Re CBD AND SOUTH EAST LIGHT RAIL PROJECT ENVIRONMENTAL IMPACT STATEMENT

As a commuting cyclist from Randwick to the City I am concerned at the superficial consideration given to pedestrian safety in the project Environmental Impact Statement (EIS). The proposal as exhibited removes off road cycling infrastructure on Wansey Rd and Alison Rd and attracts many pedestrians waiting for or alighting from trams. Mixing pedestrians and bicycles on a 2 meter wide footpath will most likely result in collisions.

Figure 3-11: 2021 AM Peak CSELR Boardings and Mode of Access by Light Rail Stop⁸⁶

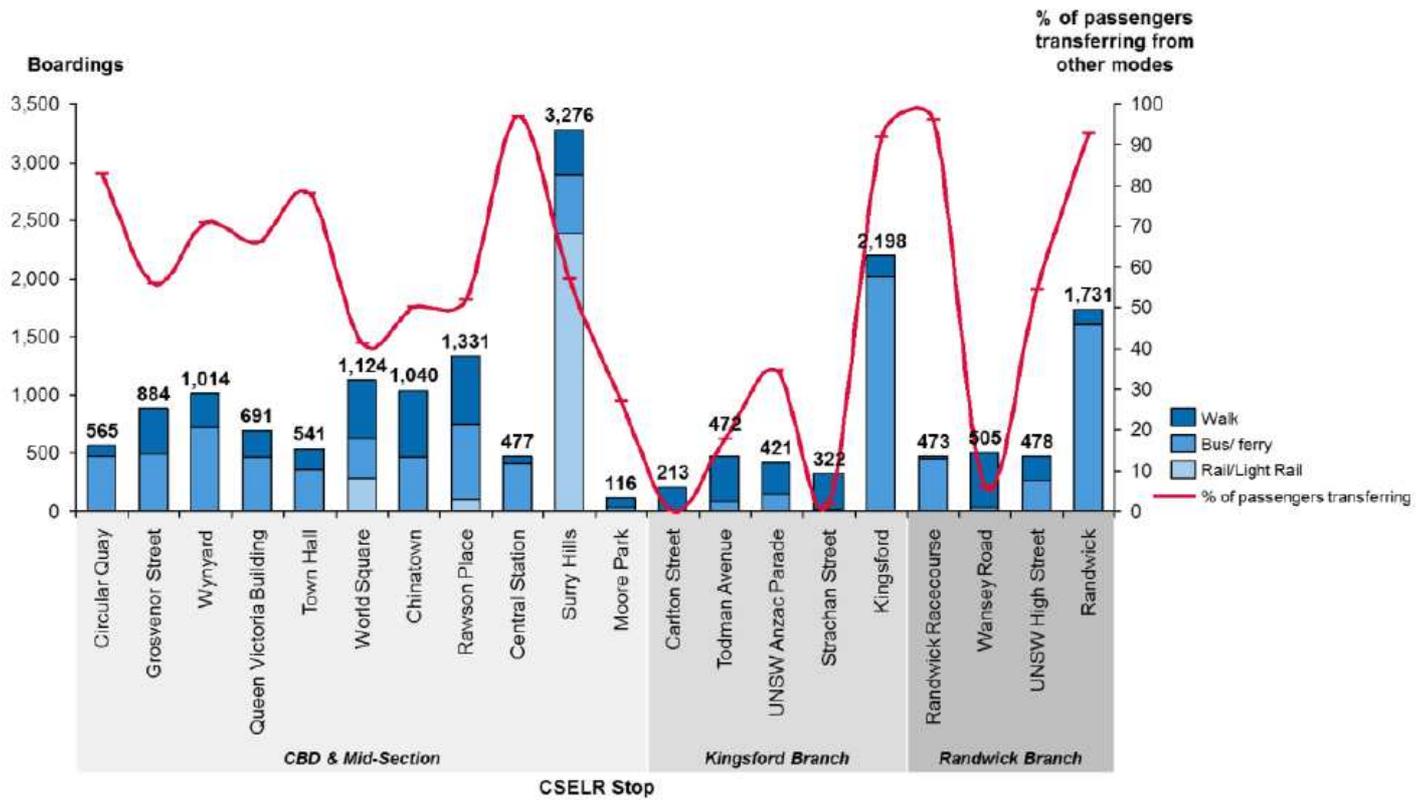
Page 117 of the EIS indicates 505 pedestrians join the inbound AM peak light rail at Wansey Rd (north) and 478 pedestrians inbound AM peak light rail join at Wansey Rd (South) or UNSW. There does not appear to be data provided in the EIS on the outbound AM peak. The Wansey Rd (South) or UNSW stop will have a large number of pedestrians alighting the light rail and stepping into the "shared" pedestrian cycleway. In the absence of any data, this may mean that the Wansey Rd UNSW High St stop has close to 1,000 pedestrian movements an hour competing with cyclists in a pathway no more than 2m wide!

With 500 pedestrians per hour waiting for light rail trams, accidents will occur until Randwick City Council is obliged to remove cyclists from the pathway. Some cyclists to avoid pedestrians will migrate from the dedicated off road cycle path to the single lane Wansey Rd. Pedestrian and / or cyclists fatalities are unfortunately imaginable with the current design.
